SANDSTONE PRECINCT

DESIGN REVIEW PANEL - ADVICE 13

13 July 2020

TITLE
FAÇADE DETAILS - EDUCATION BUILDING - GLASS BAY

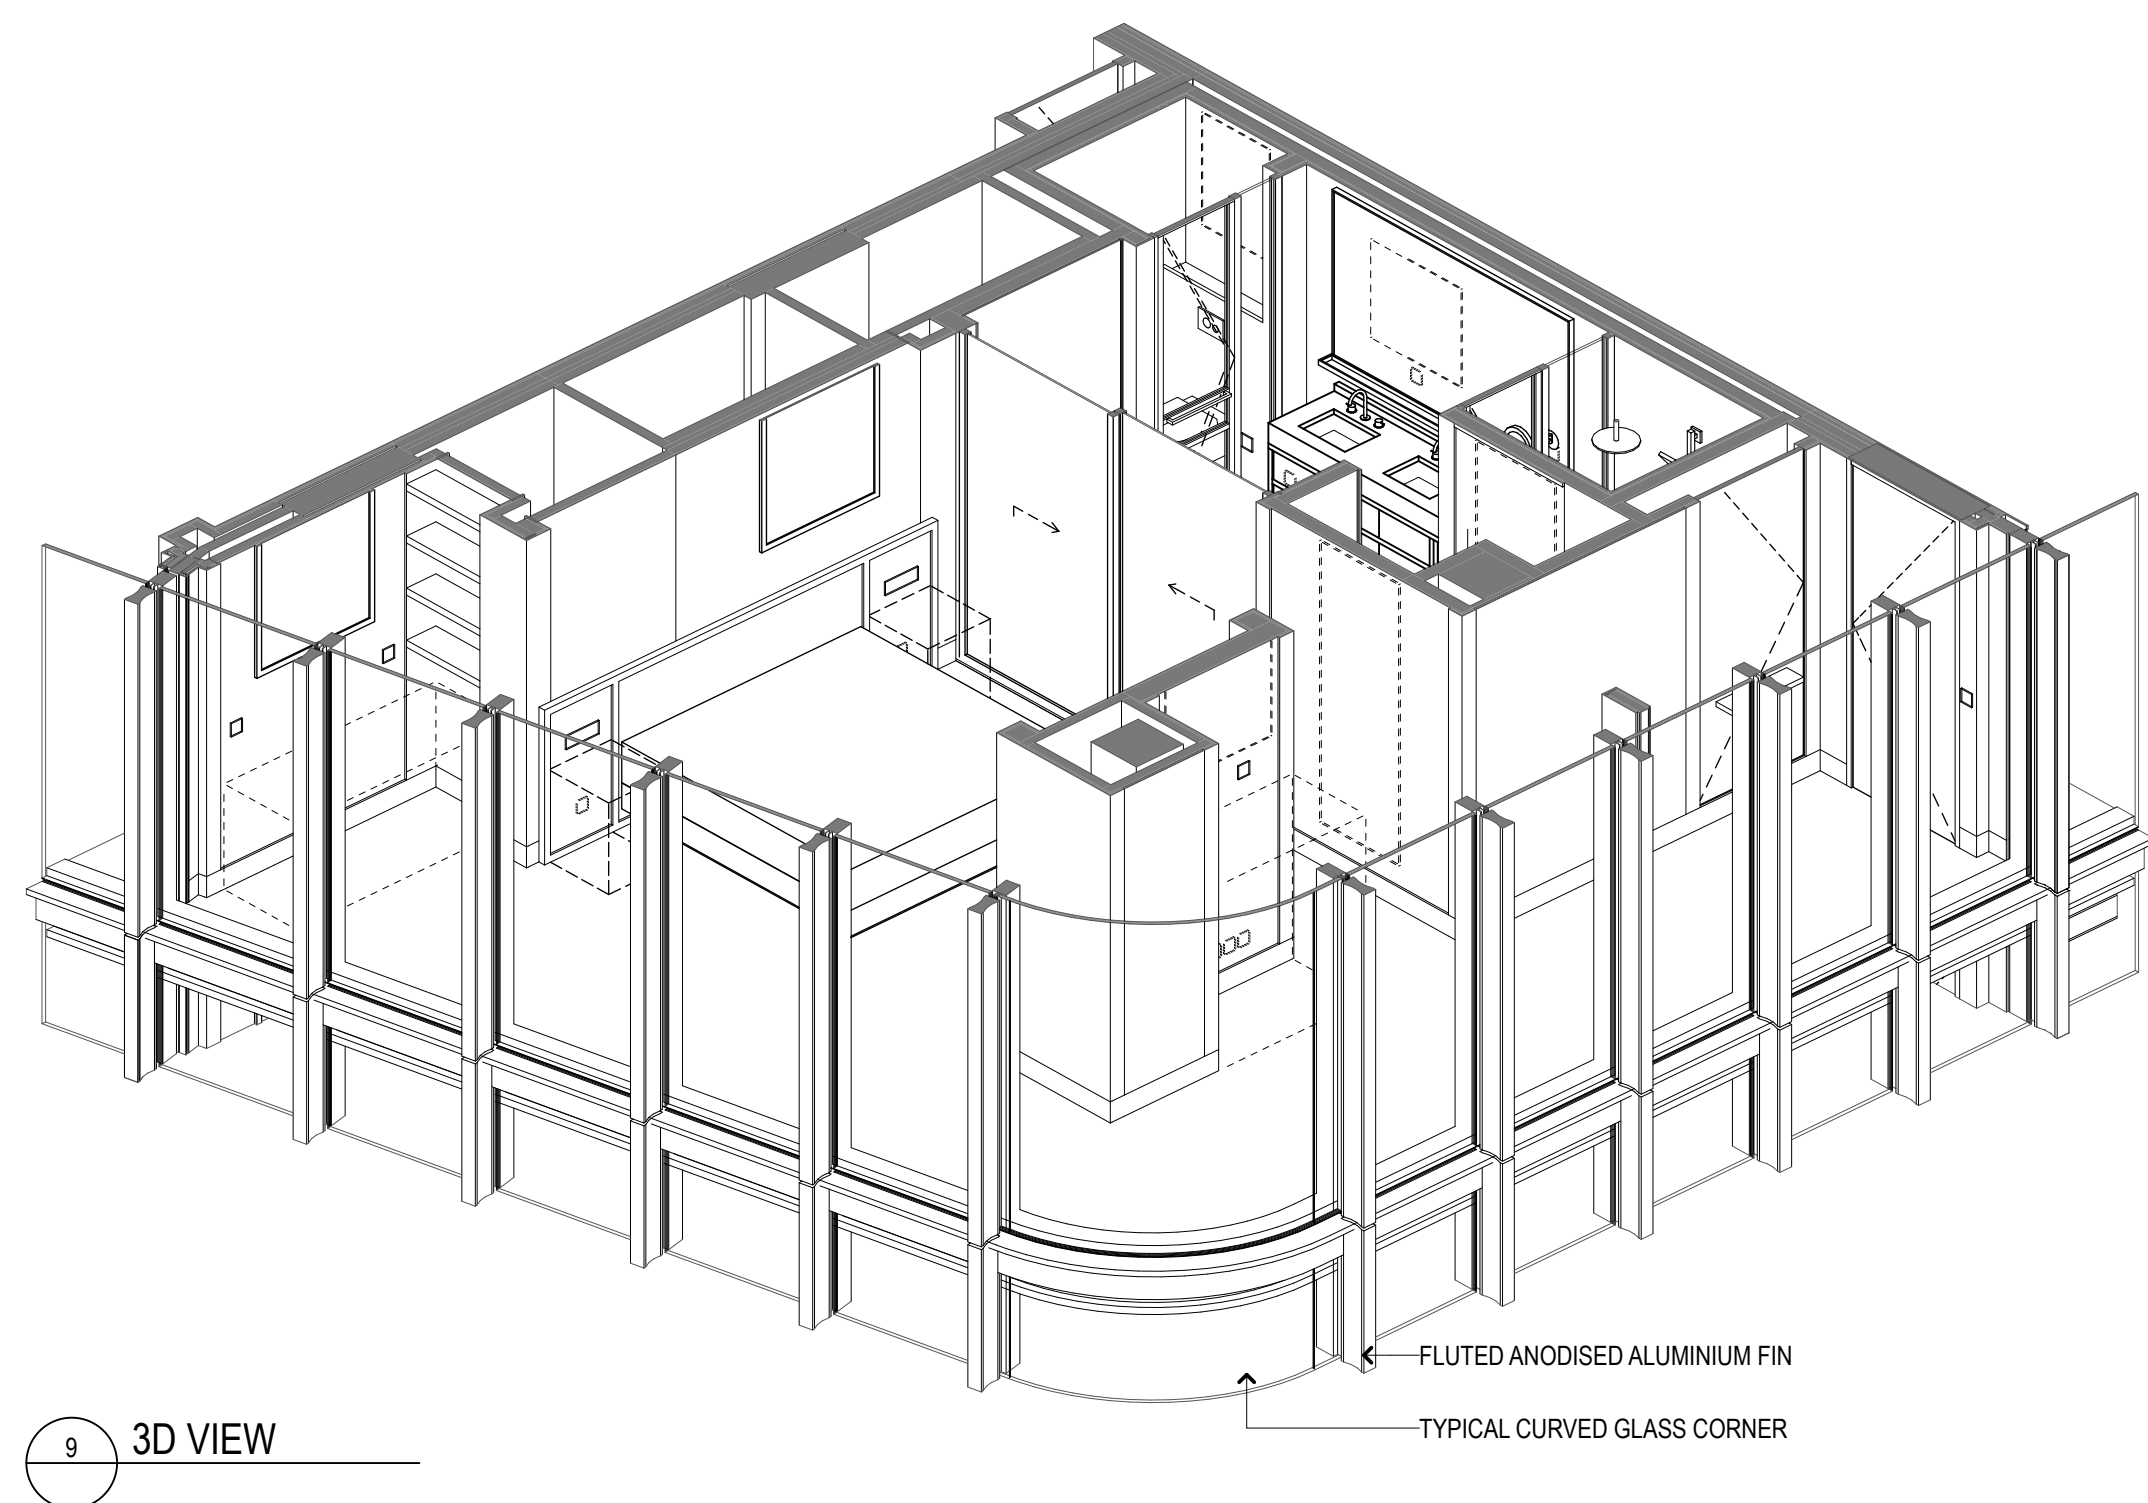
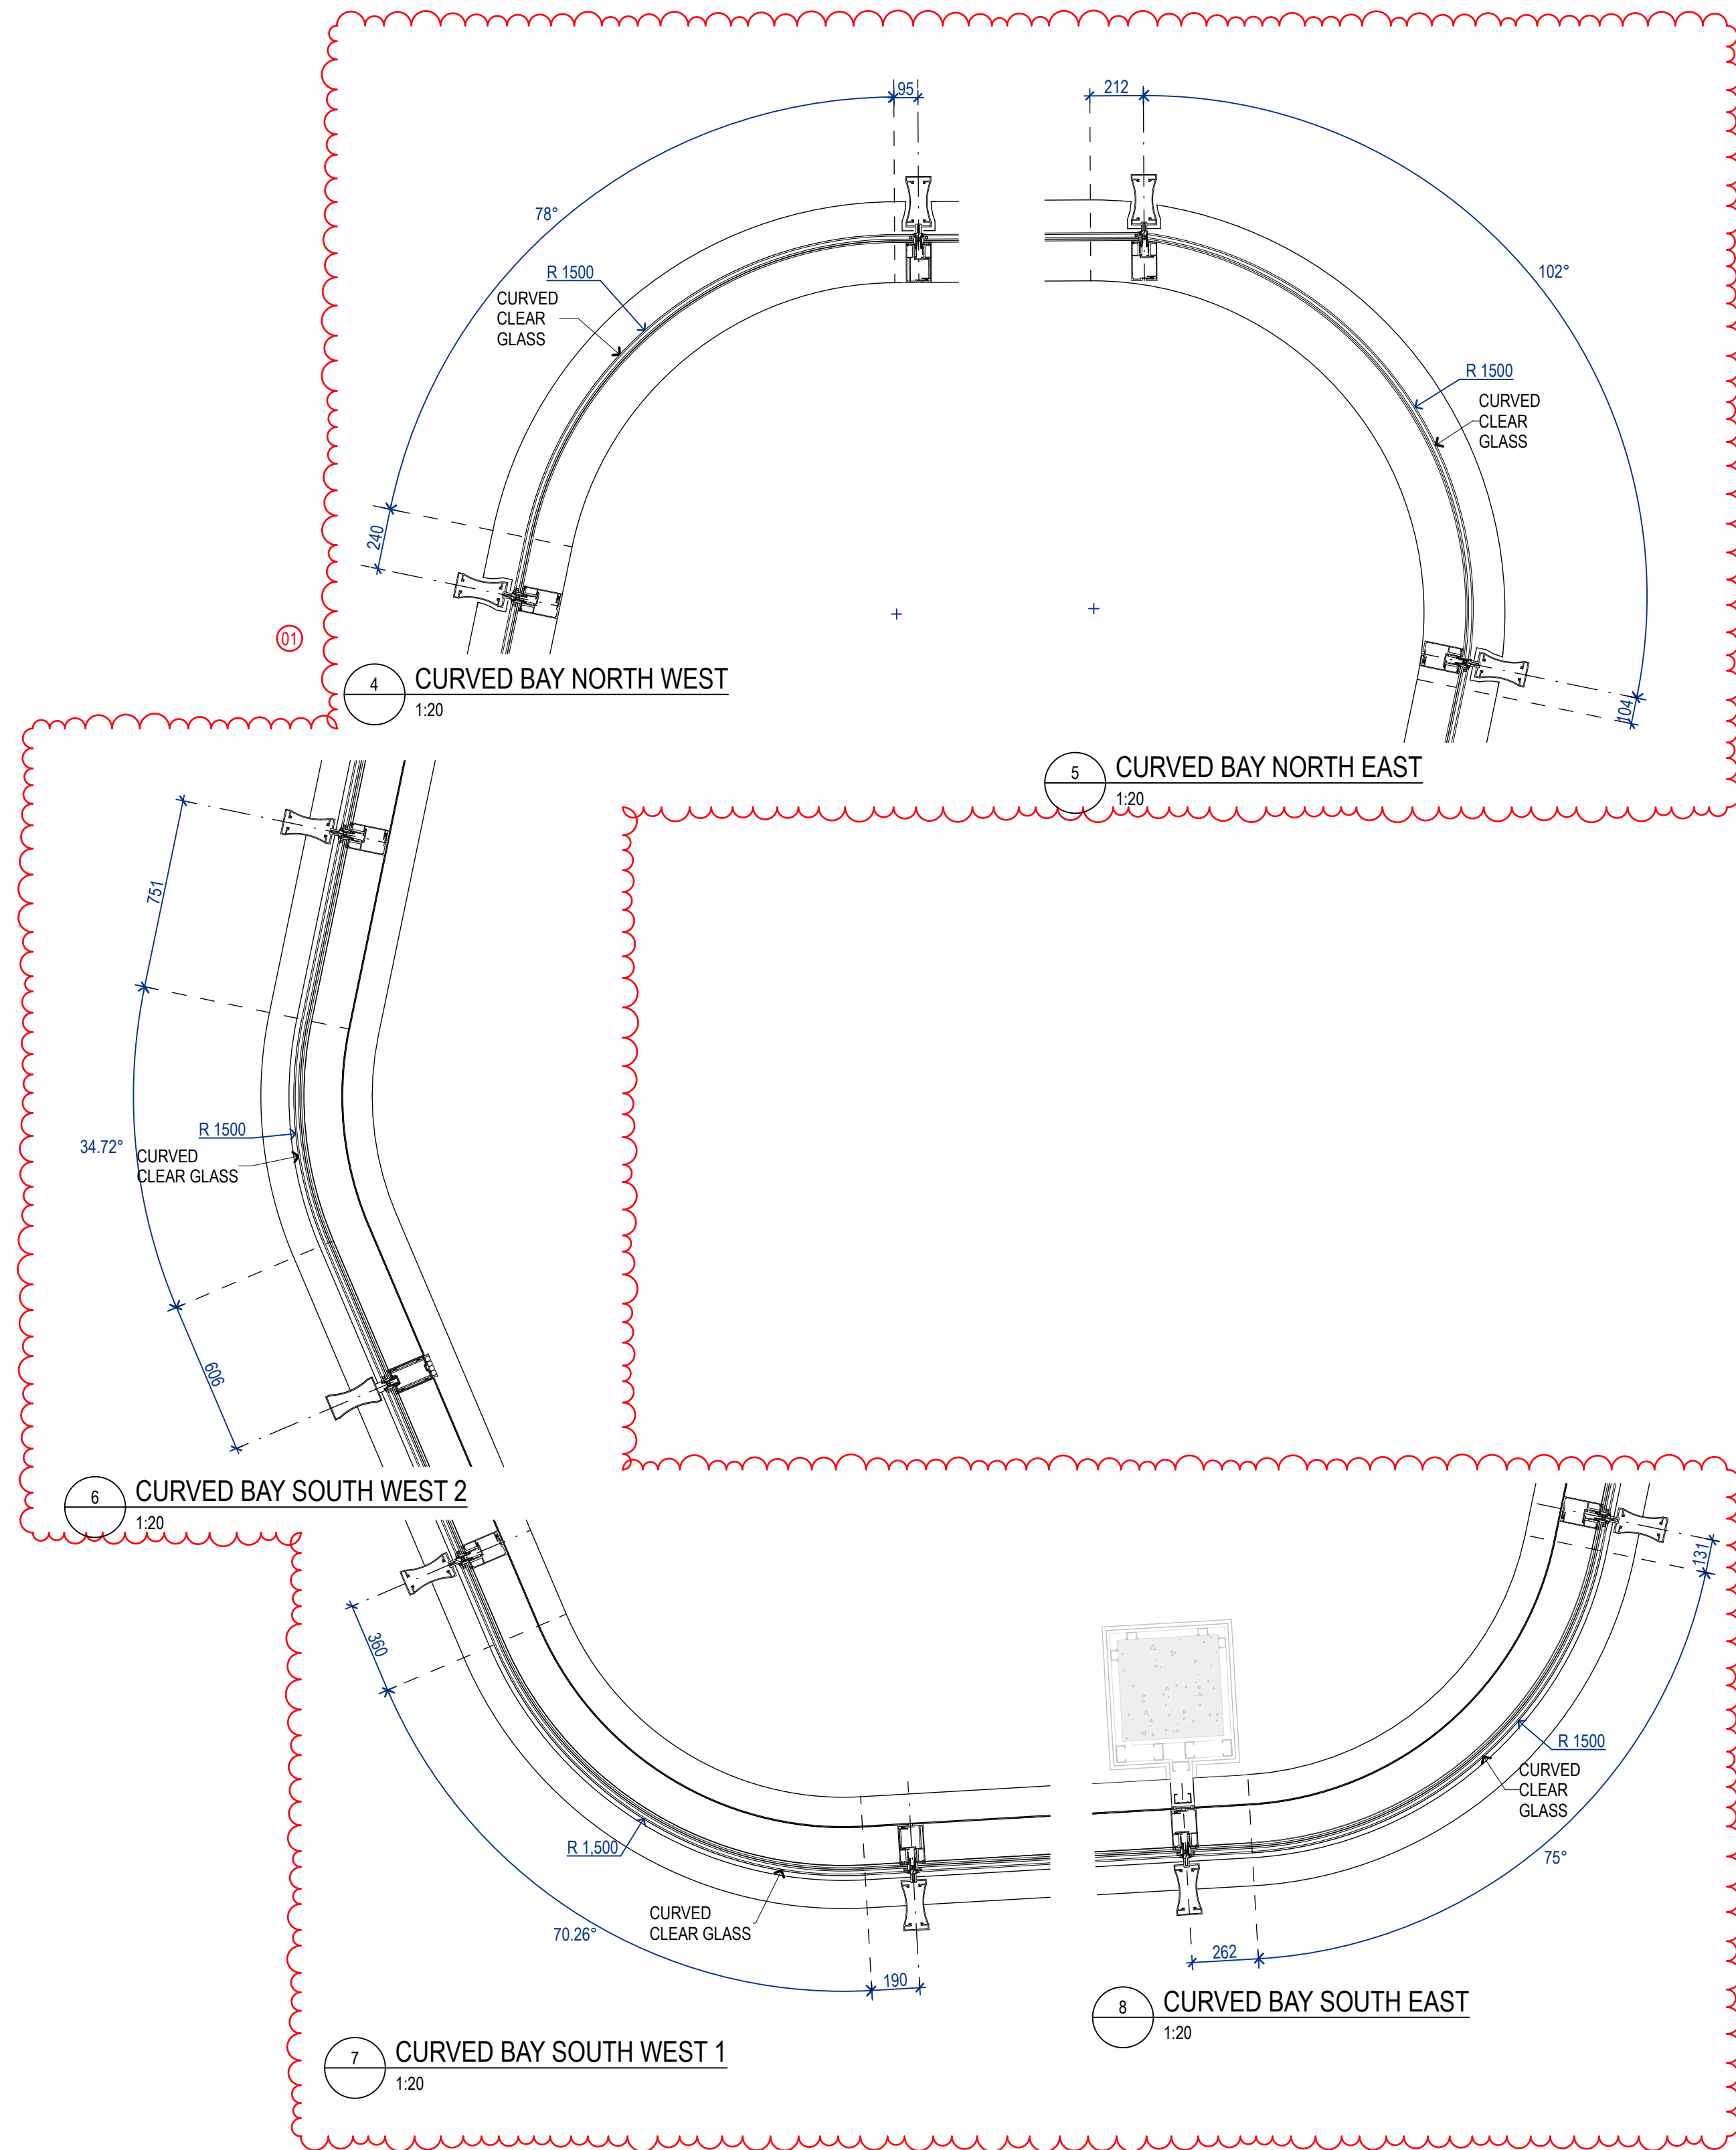
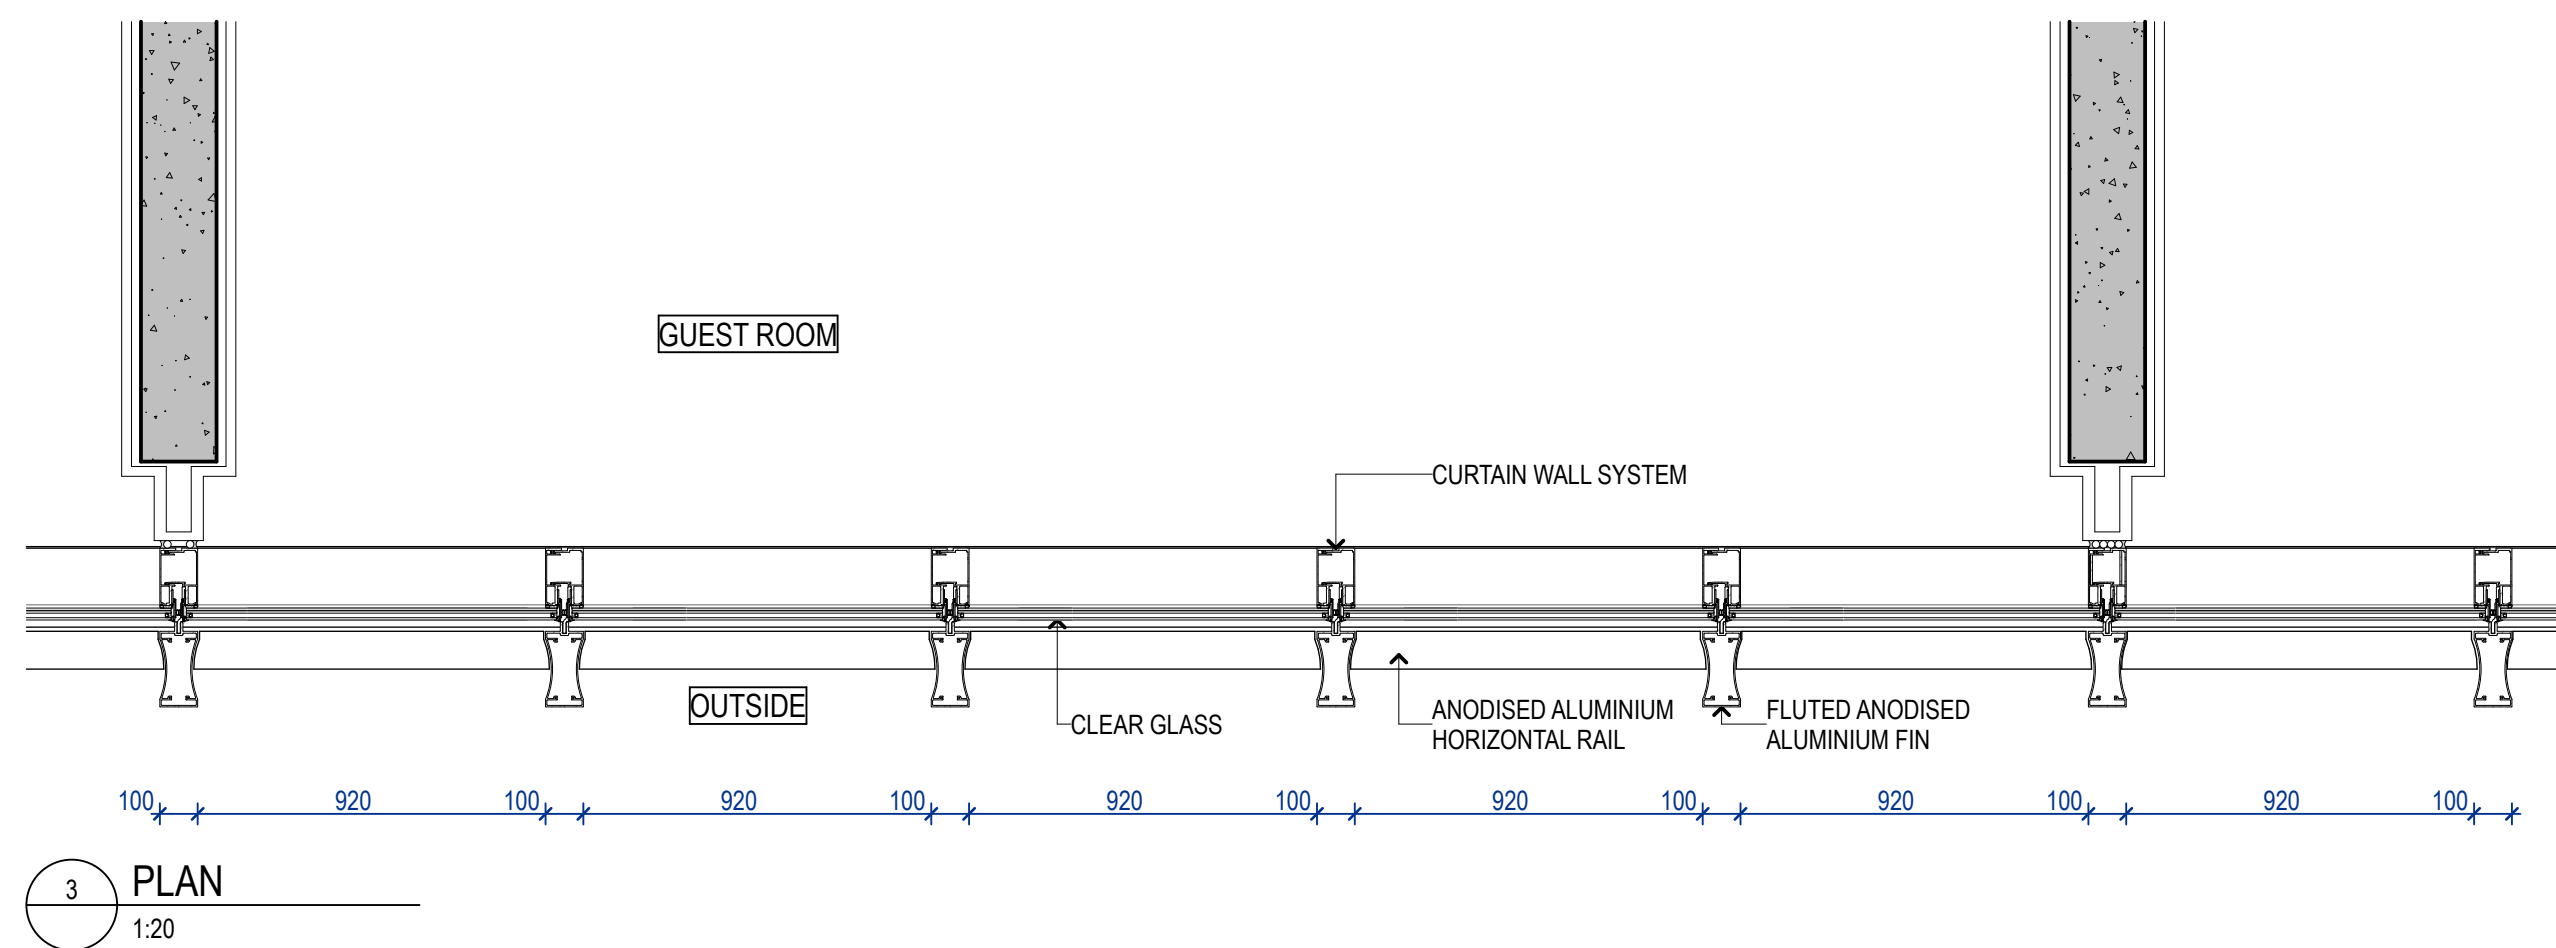
- . *Curved glass radius increase to 1500mm (External and Internal) & Mullion adjustment around curved glass corners.*
- . *External North elevation changes to cladding on level 9*
- . *External East elevation hidden door relocation on level 9*

The Panel supports these changes.
